Demolish 1 house (60 Sea Lane); partially demolish 1 house (45 The Ridings); construct 3 detached houses; alterations and extensions (45 The Ridings)
45 The Ridings and 60-62 Sea Lane East Preston

Re: Planning Application EP/111/12 – Land south of 45 The Ridings and 60 Sea Lane

The Planning Committee of this council considered this Application at its meeting on 14th May 2013.

STREET SCENES

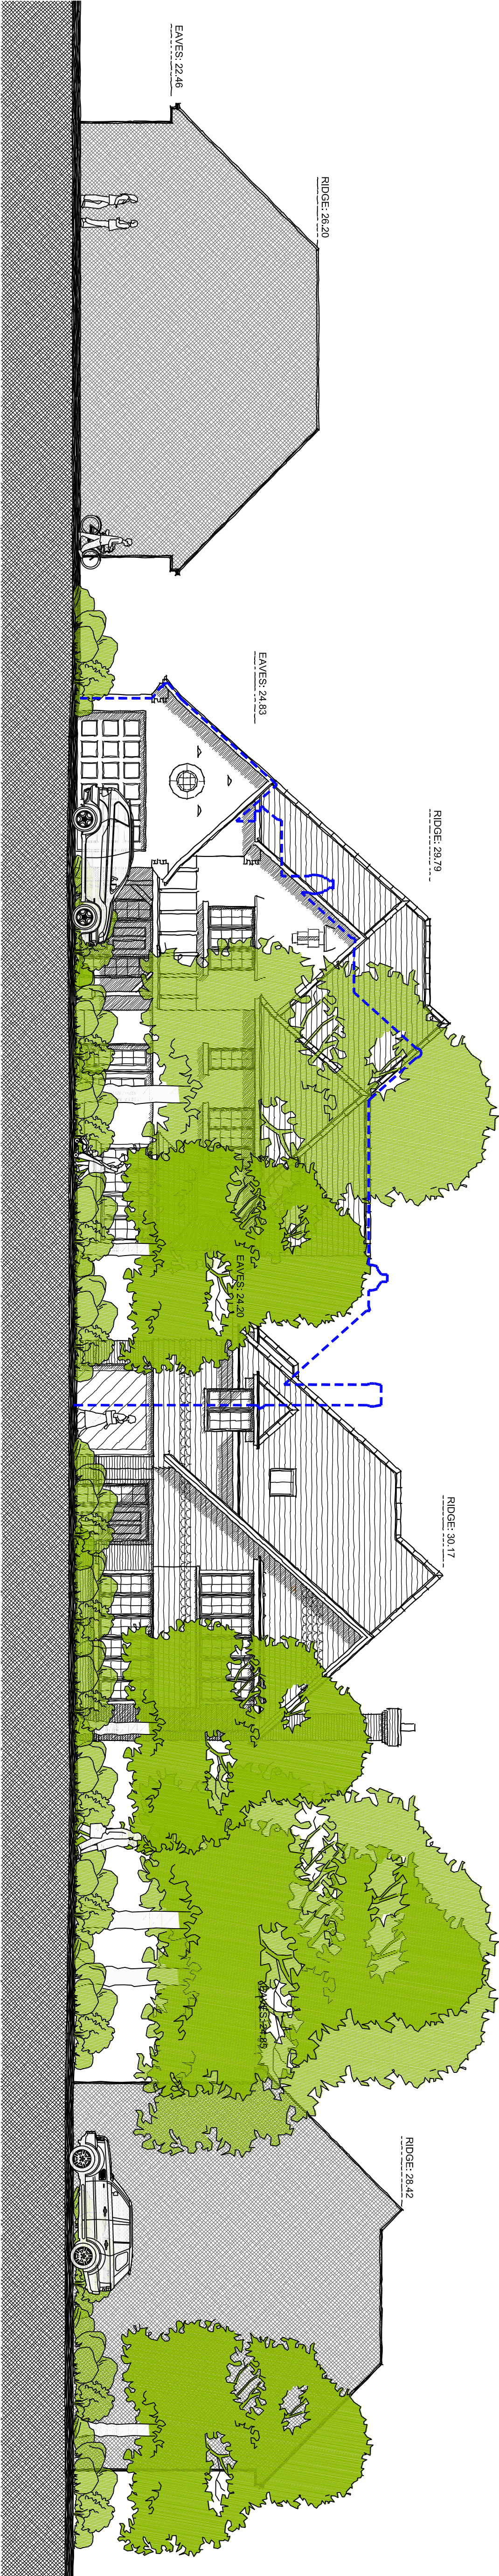
Overbearing – the height of the proposed 47 The Ridings will be significantly higher than the existing 49 The Ridings; the height of the proposed remodelled 45 The Ridings will be closer to and overbearing to 43 The Ridings and will possibly dominate 41 The Ridings. This is contrary to Policy DM17 in the emerging Local Plan which states that development should “Have minimal impact to users and occupiers of nearby property and land. For example [...] having an over-bearing presence.” This is also contrary to the design guidelines in the East Preston Village Design Statement.

PROPOSED FLOOR PLANS &
ELEVATIONS
NO. 45 THE RIDINGS

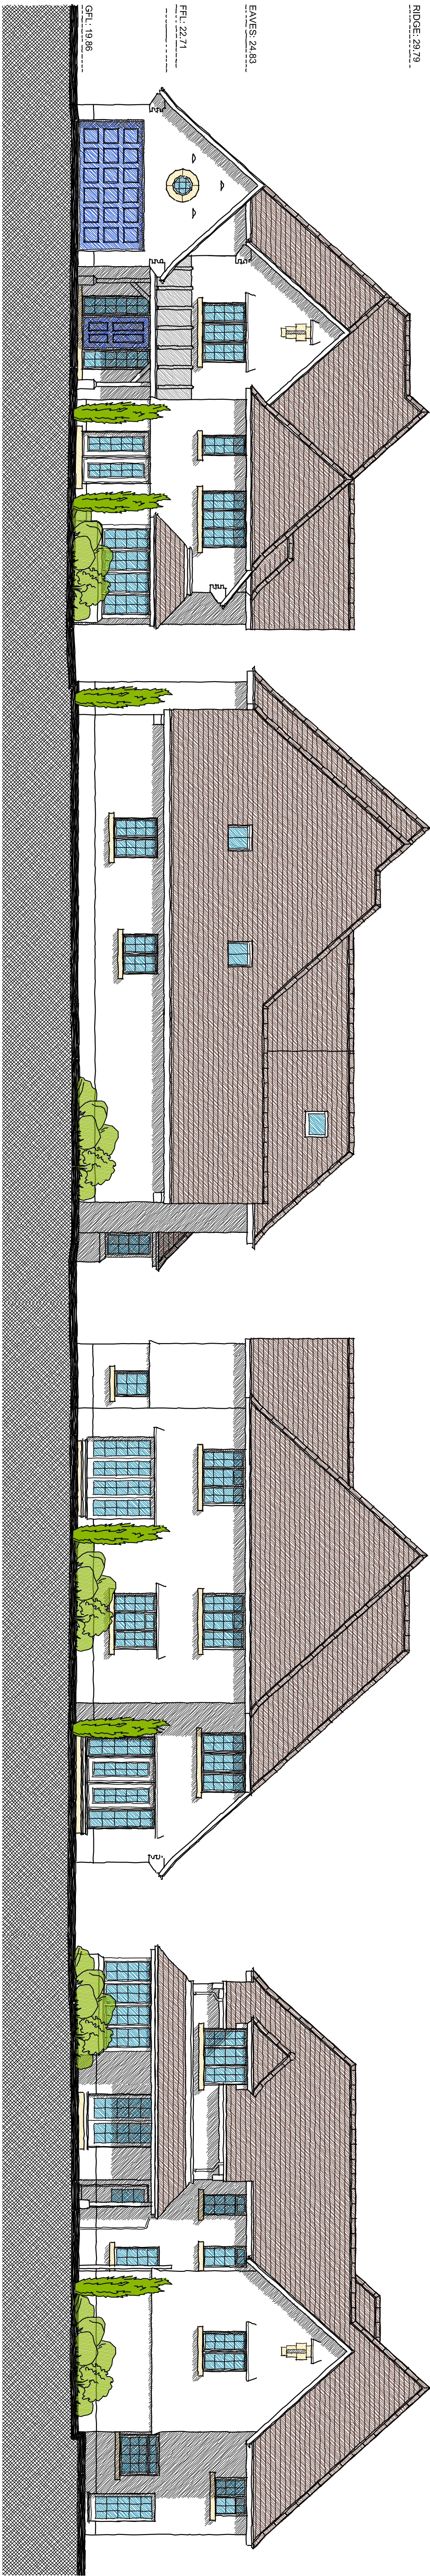
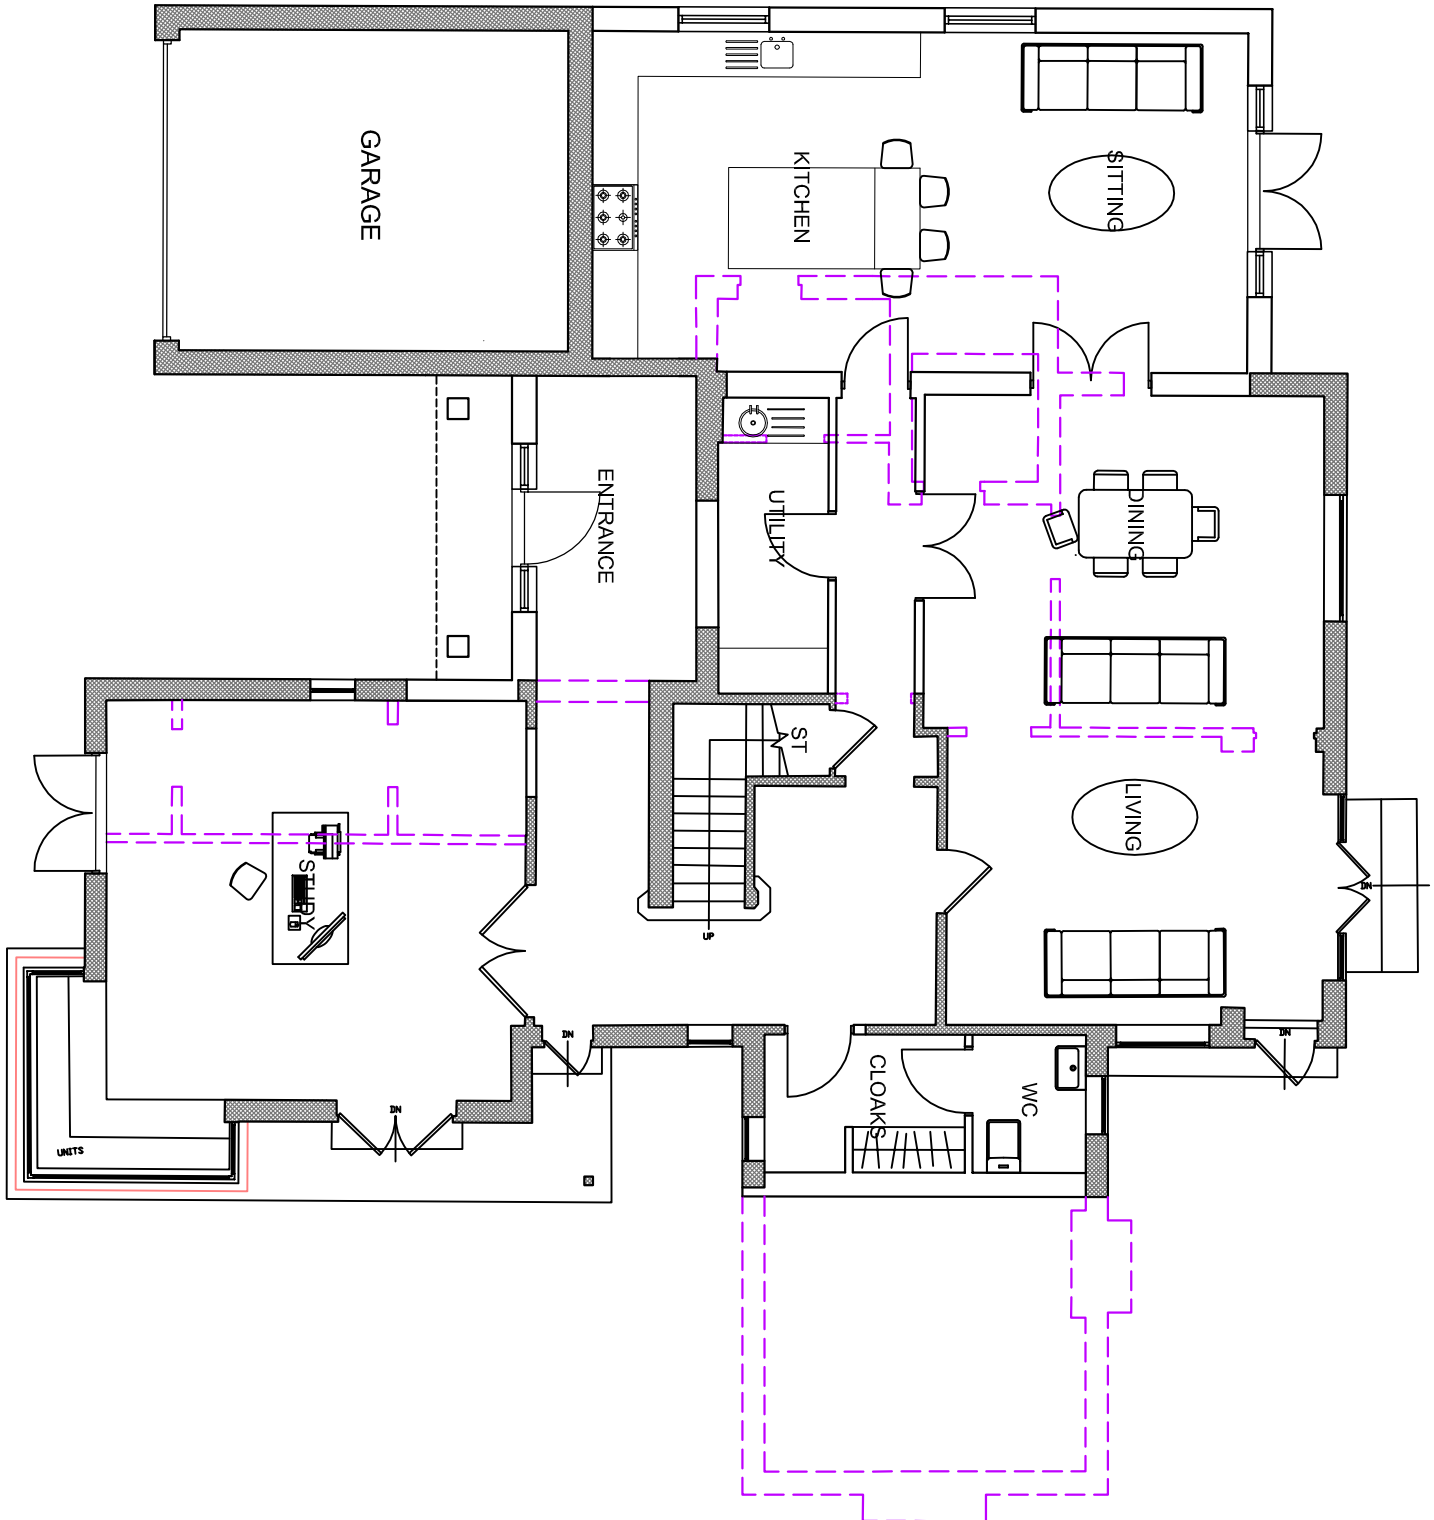
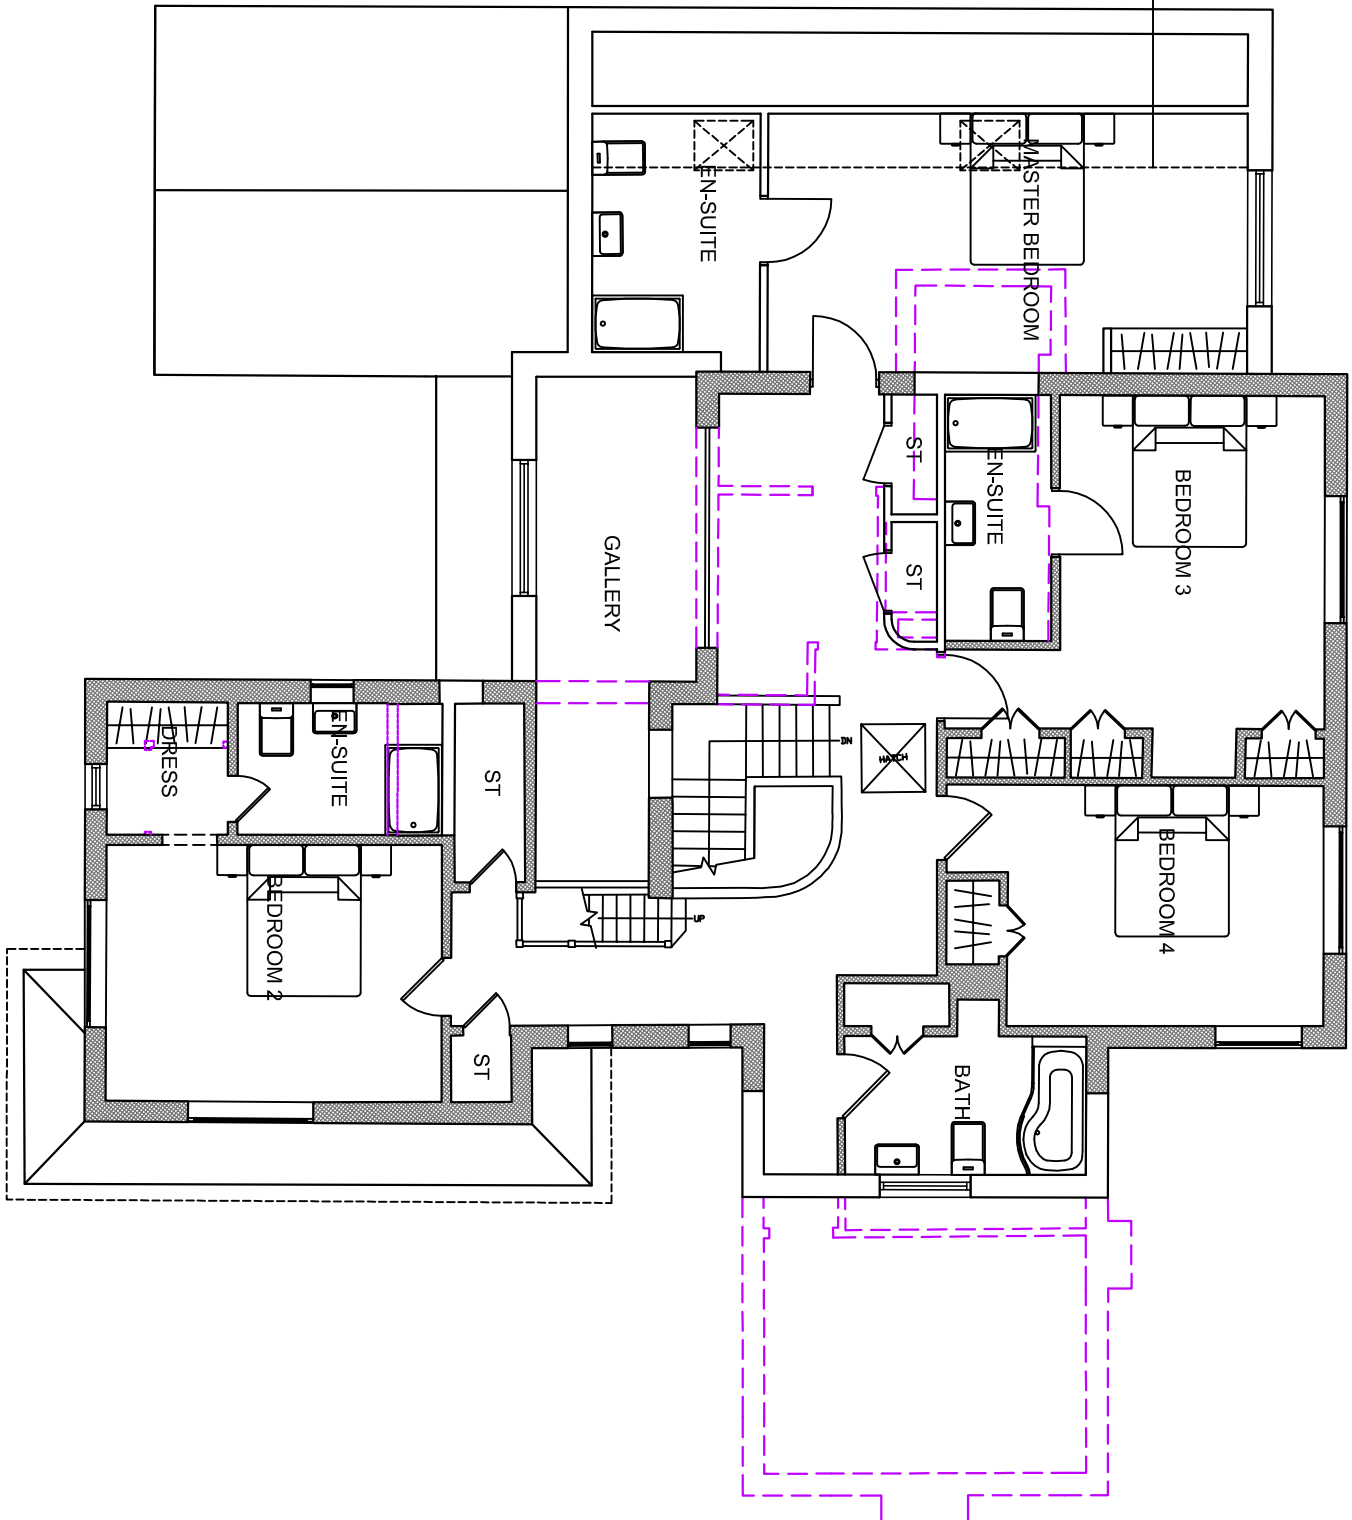
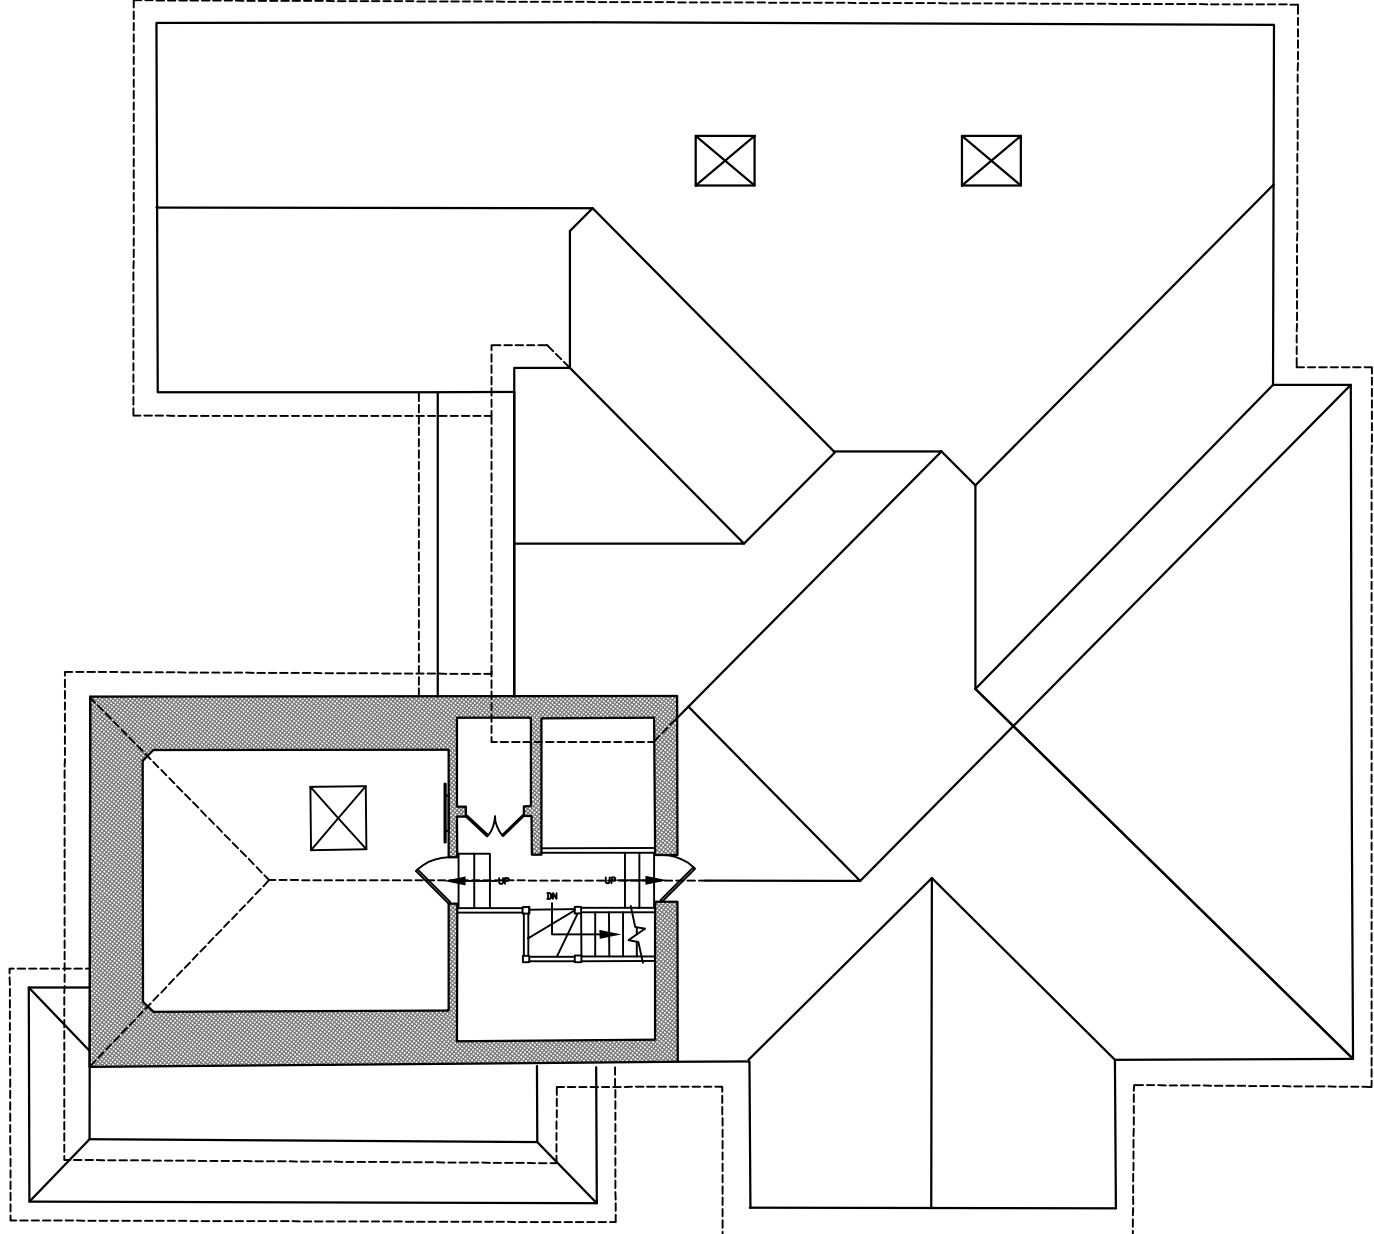
The bulk of the properties is not acceptable, especially the increased bulk on the northern side of 45 The Ridings.
